Consultee response

EP/80/20/HH & EP/81/20/L

Vista Point 21 Tamarisk Way East Preston BN16 2TE

Planning and Listed building consent to convert 2 existing garages to habitable accommodation to create a new family living space and enclose the existing outdoor link from the main house to the garage to form an indoor warm/dry link with alterations to the landscaping arrangements.

Drawing number
AA-18064-GA-10-10

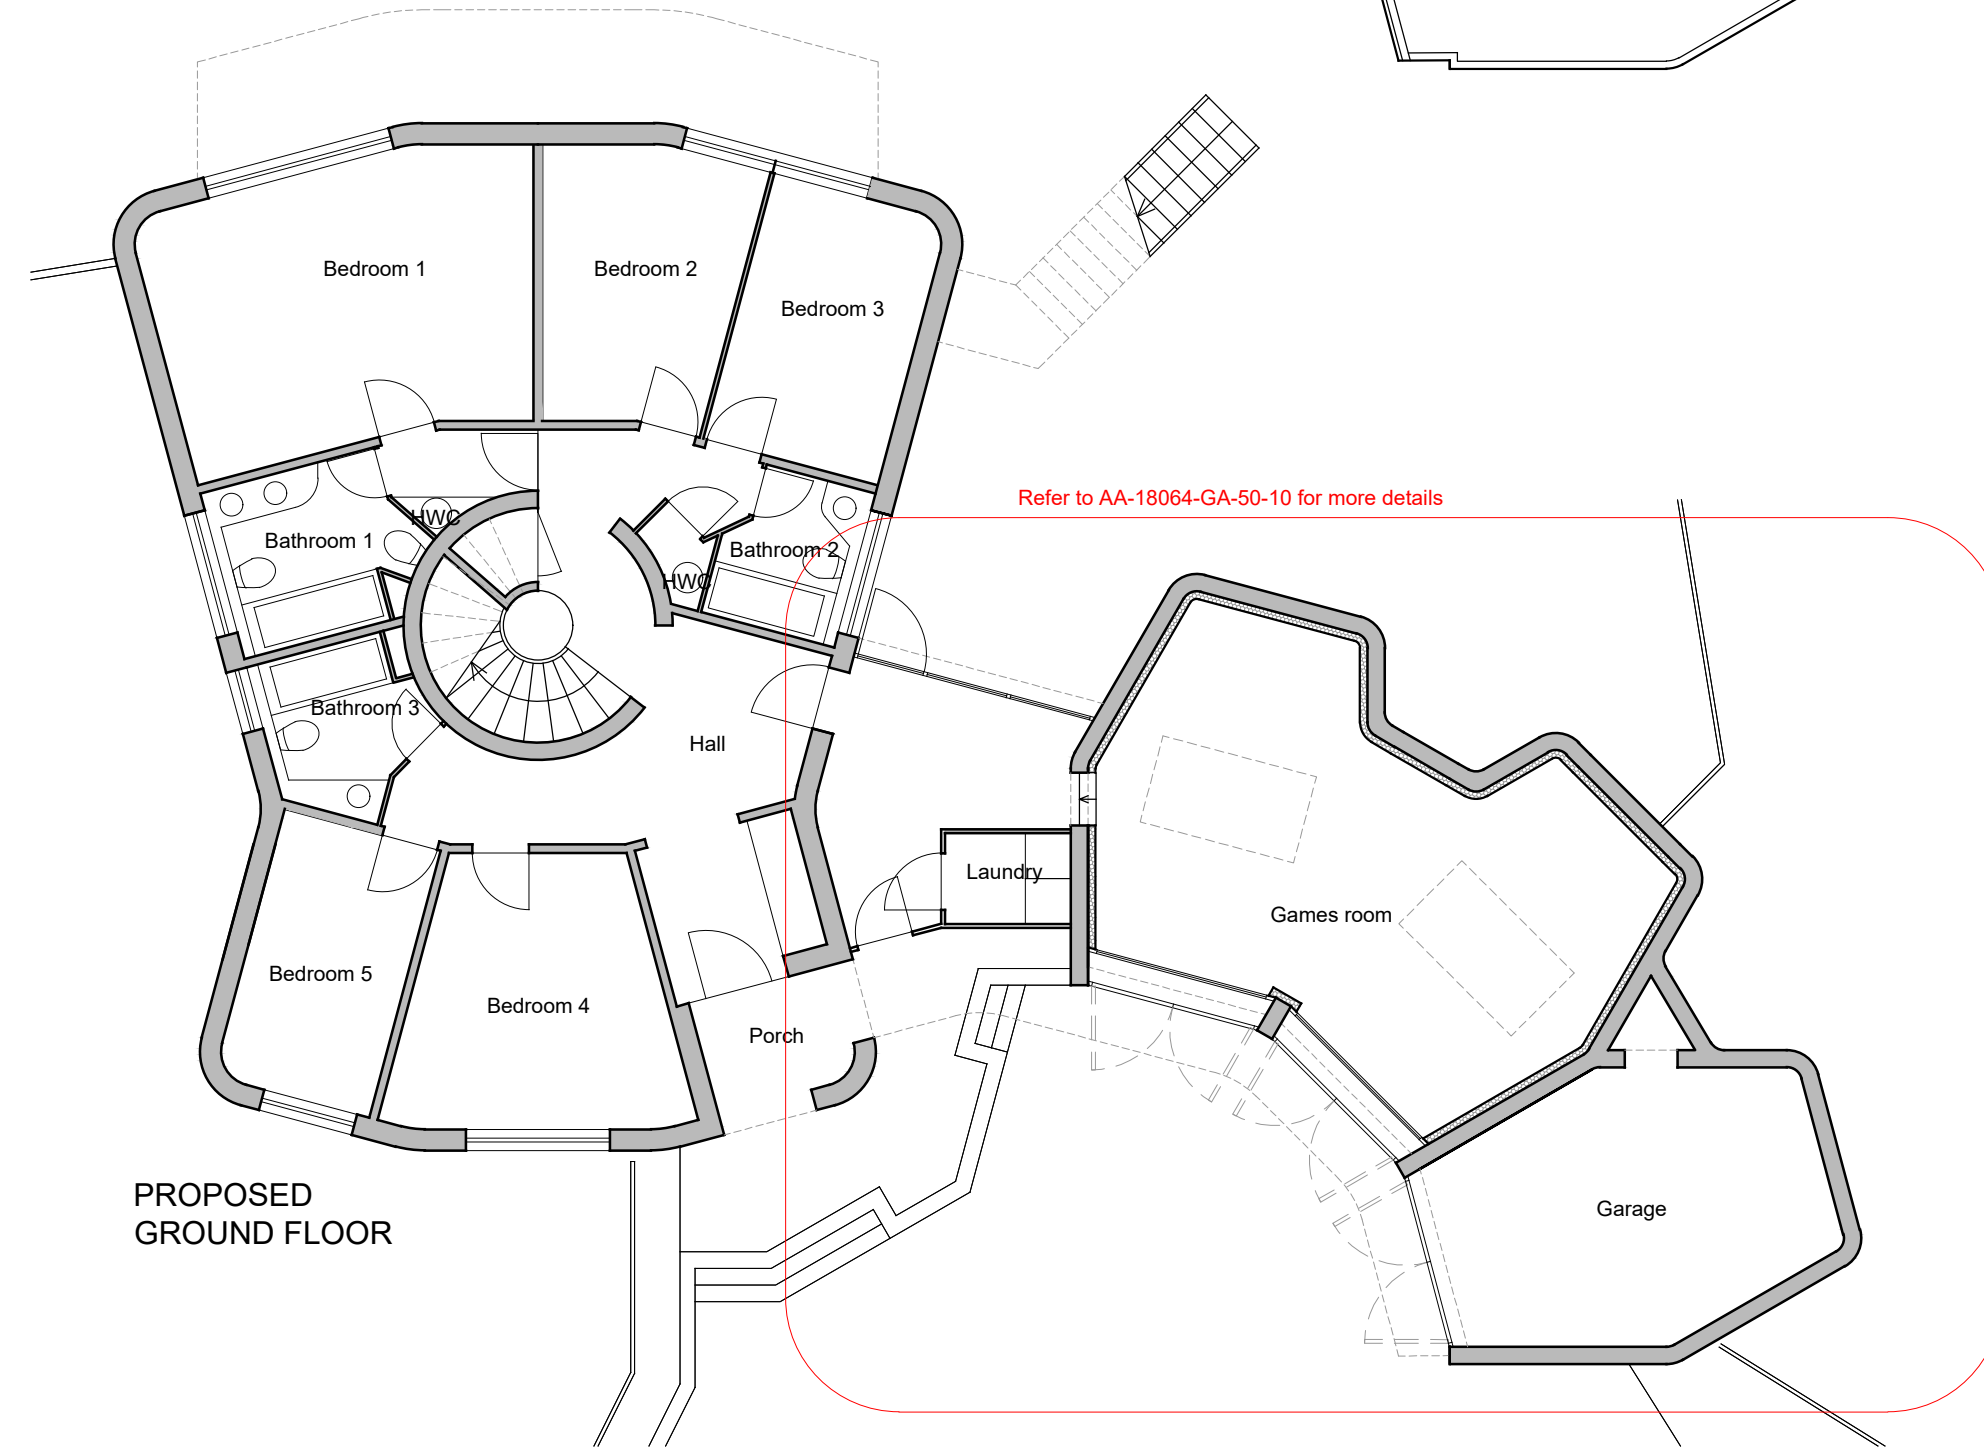
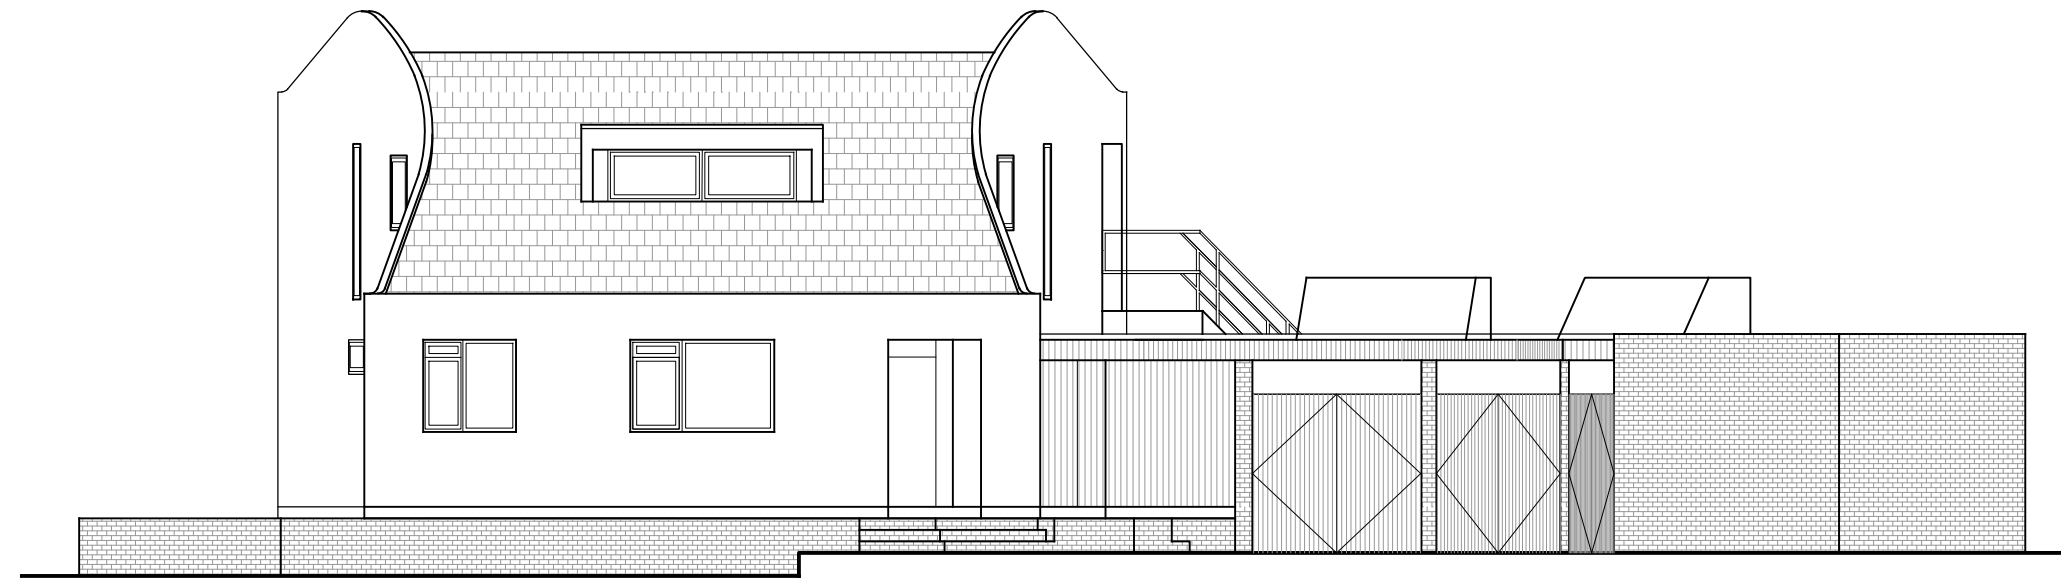
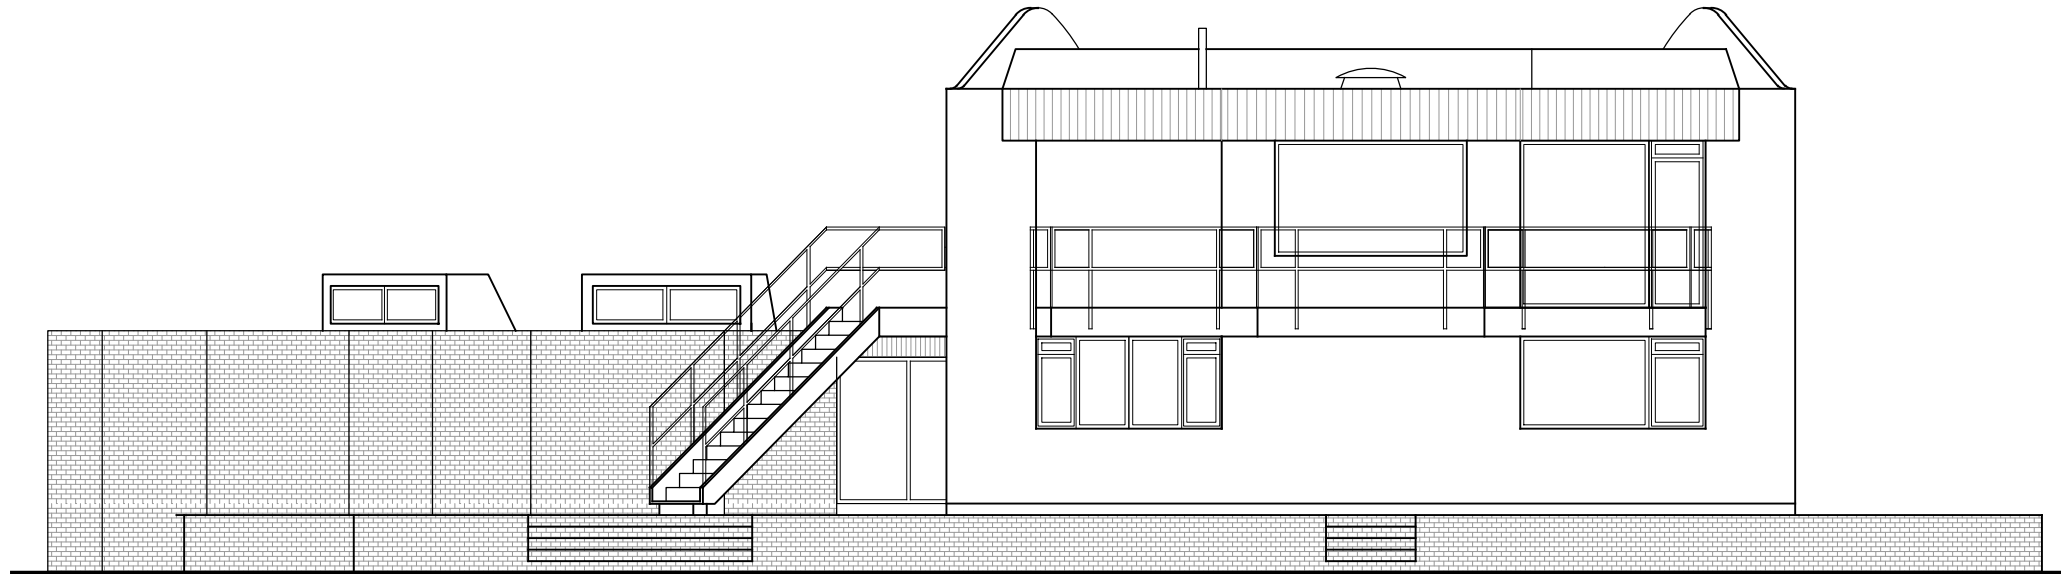
It is considered that as long as this element of the proposal only affected the rear elevation of the space, it will have a neutral impact upon the building. However, this is on the basis that the new glazing should closely reflect that of the existing building. If minded to approve the application, you may wish to request further details of the glazing by way of condition.
